Fw: Y/42/26/L Bonhams Farm House

From: Martyn White <Martyn.White@arun.gov.uk> on behalf of Conservation Officer <Conservation.Officer@arun.gov.uk>
Sent: 07 August 2026 16:01
To: Rhiannon Lloyd <Rhiannon.Lloyd@arun.gov.uk>
Subject: FW: Y/42/26/L Bonhams Farm House

Re: proposed option a or b for the floor.

Long Section proposed

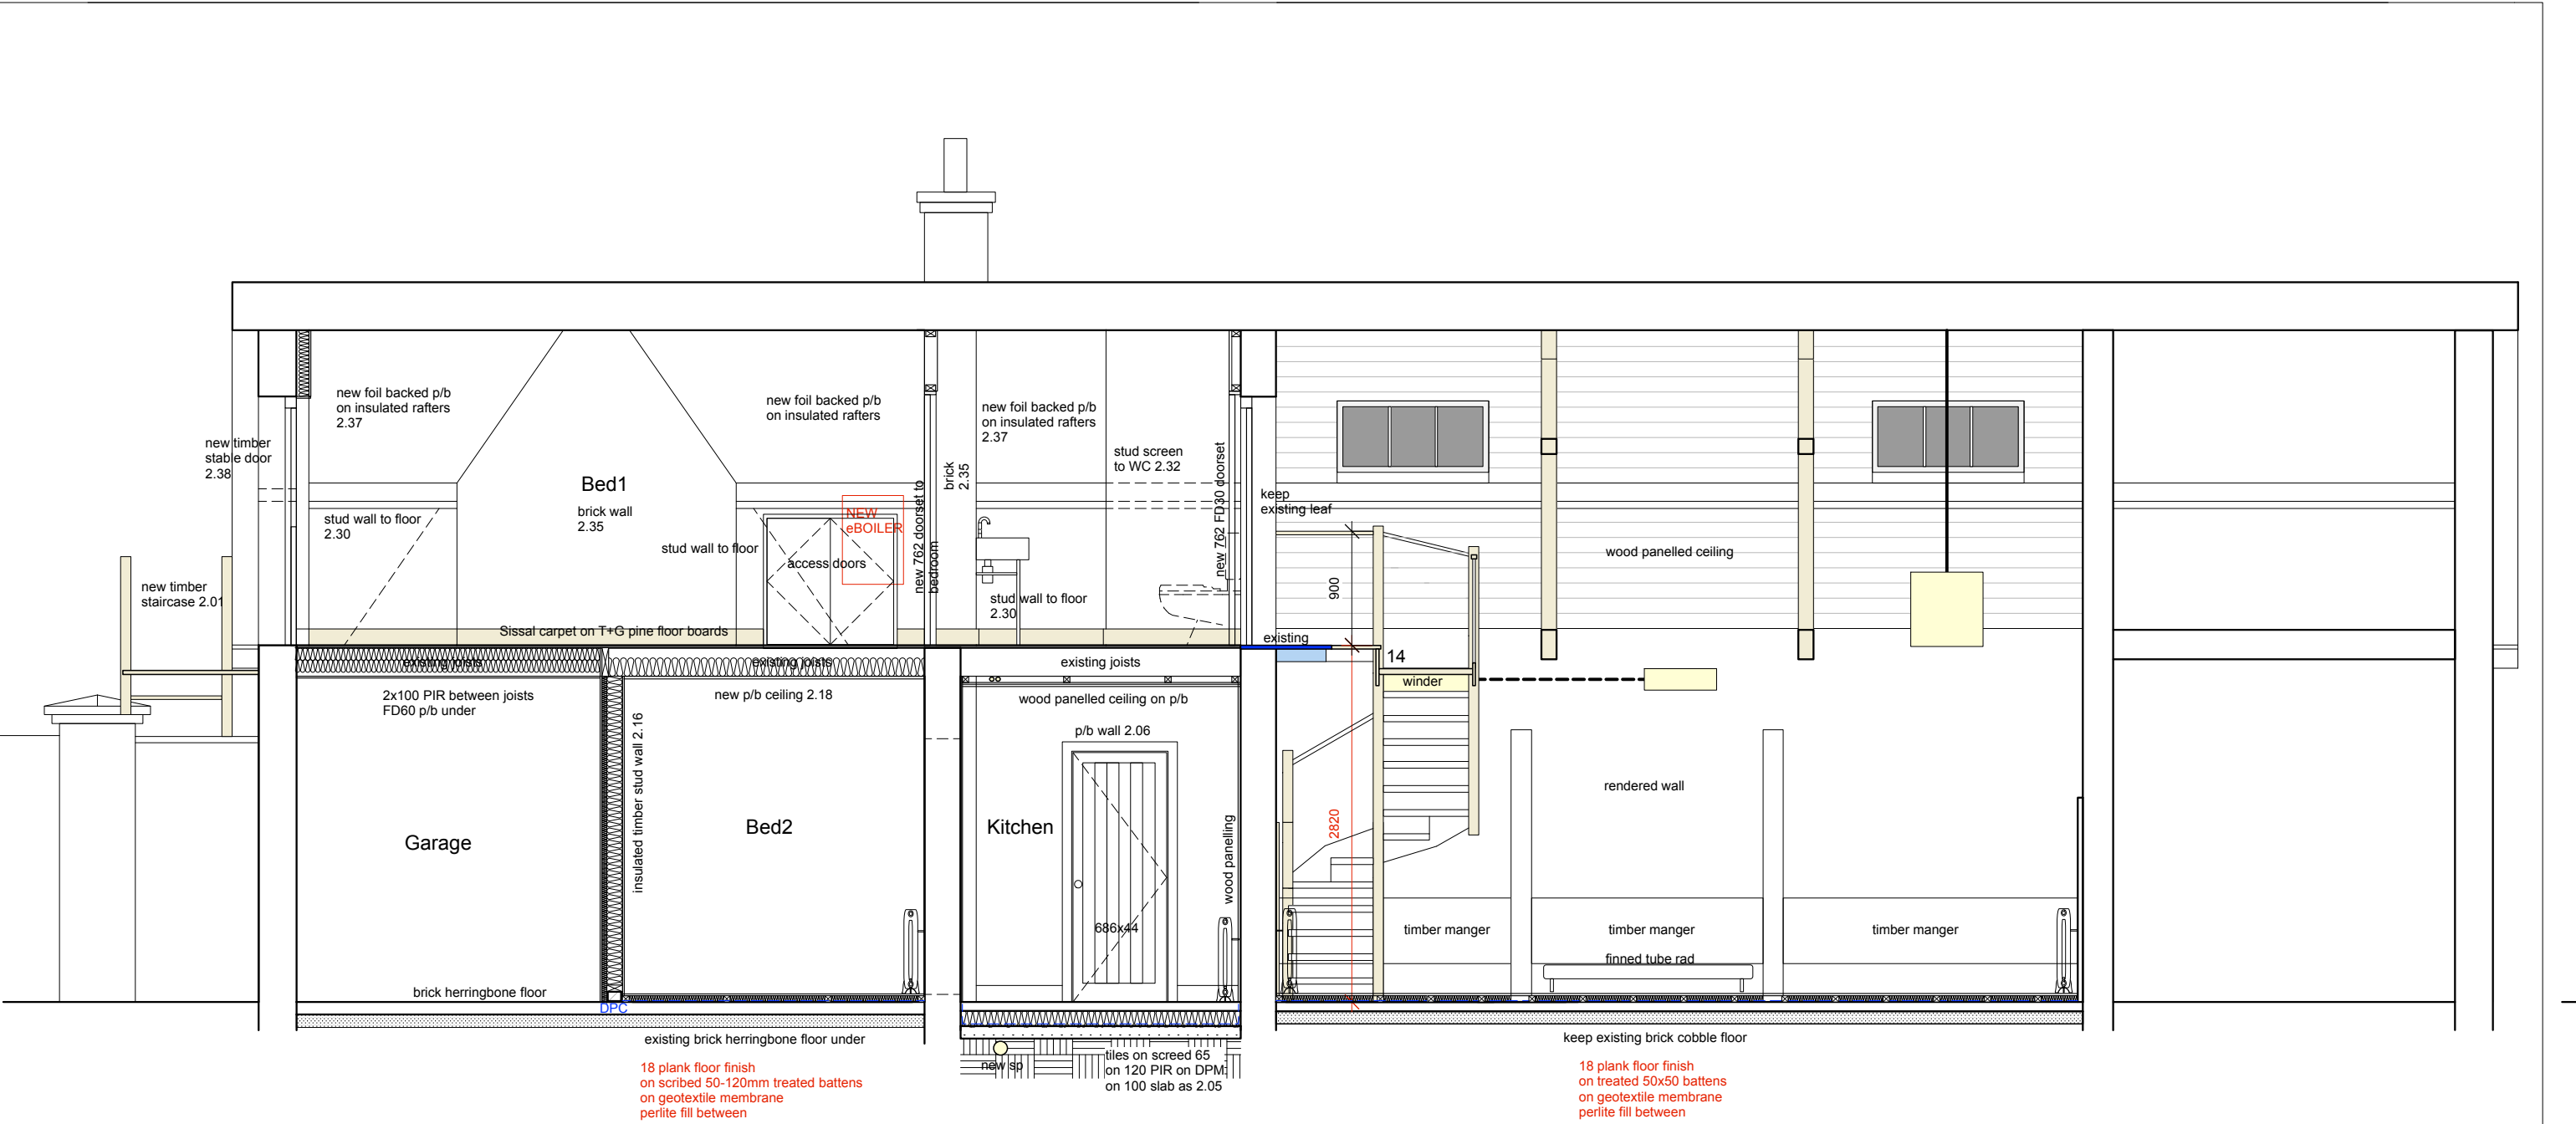
Having reviewed the information provided, it appears that the proposed floor construction retains the historic brick floor in situ beneath the new flooring and has been designed using breathable materials throughout. The submission also states that the geotextile membrane will prevent the insulation fill from clogging the joints between the historic brick setts, thereby preserving the historic floor for future reversal. Whilst I am not in a position to comment on the technical performance of the proposed floor construction, on the basis of the information submitted I have no conservation objection to the proposal
